Our Ref: BR/265/21/DOC

Town & Country Planning Act 1990 (as amended)
Town and Country Planning (Development Management Procedure) (England) Order 2015
Approval of details reserved by condition imposed under BR/222/21/PL relating to conditions 4-
covered and secure cycle parking spaces, 5-highest available headline speed of broadband & 6-
replacement of two bird boxes on building.

Vincent House 75 Highfield Road Bognor Regis PO22 8PD

Vincent House, 75 Highfield Road, Bognor Regis. PO22 8PD
Release of conditions 4,5 & 6 for planning ref: BR/222/21/PL
Drawing no. 1

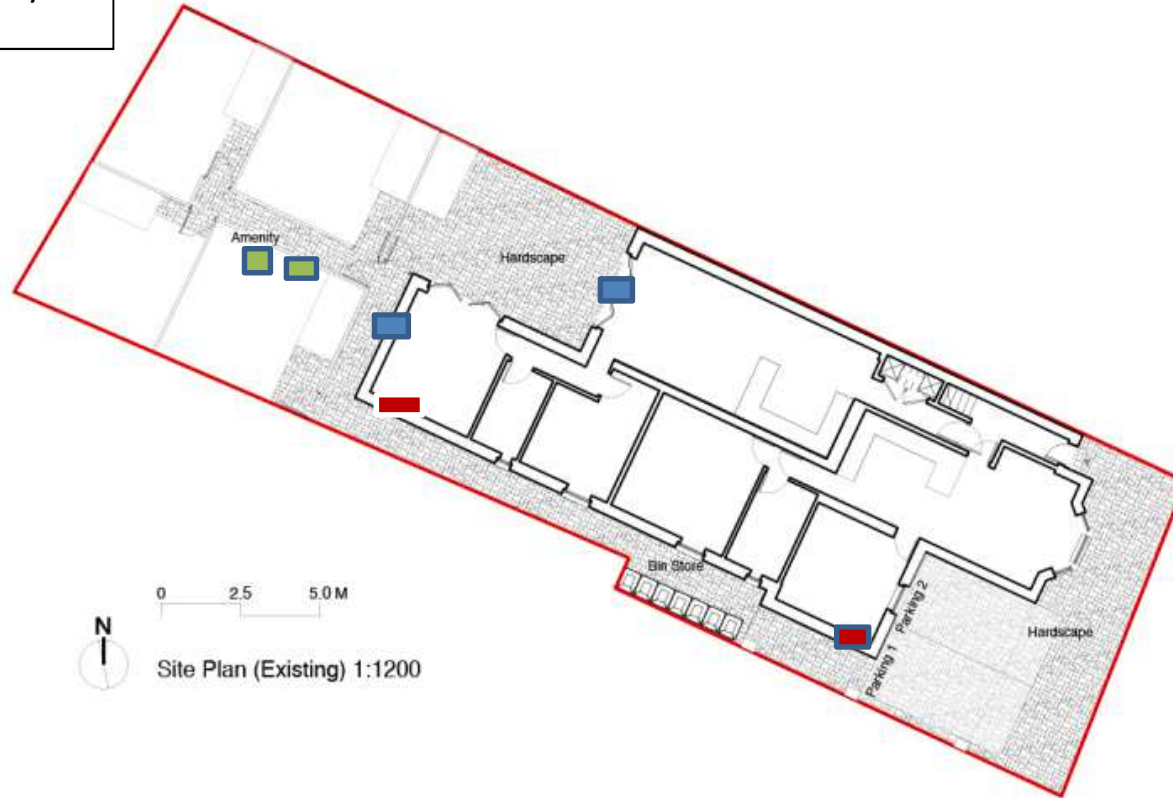
The submitted details in respect of bird boxes namely the site plan "Release of conditions 4, 5 & 6 for planning ref: BR/222/21/PL Drawing no. 1" shows the location of two bird boxes placed under the eaves of the second floor of the building.

The Council's Ecologist has assessed this provision and considers it to be acceptable such that the condition may be discharged. The condition is therefore fully discharged insofar as the submission of details relates and on the understanding that the bird boxes will be implemented in accordance with the approved details, retained and thereafter permanently maintained.
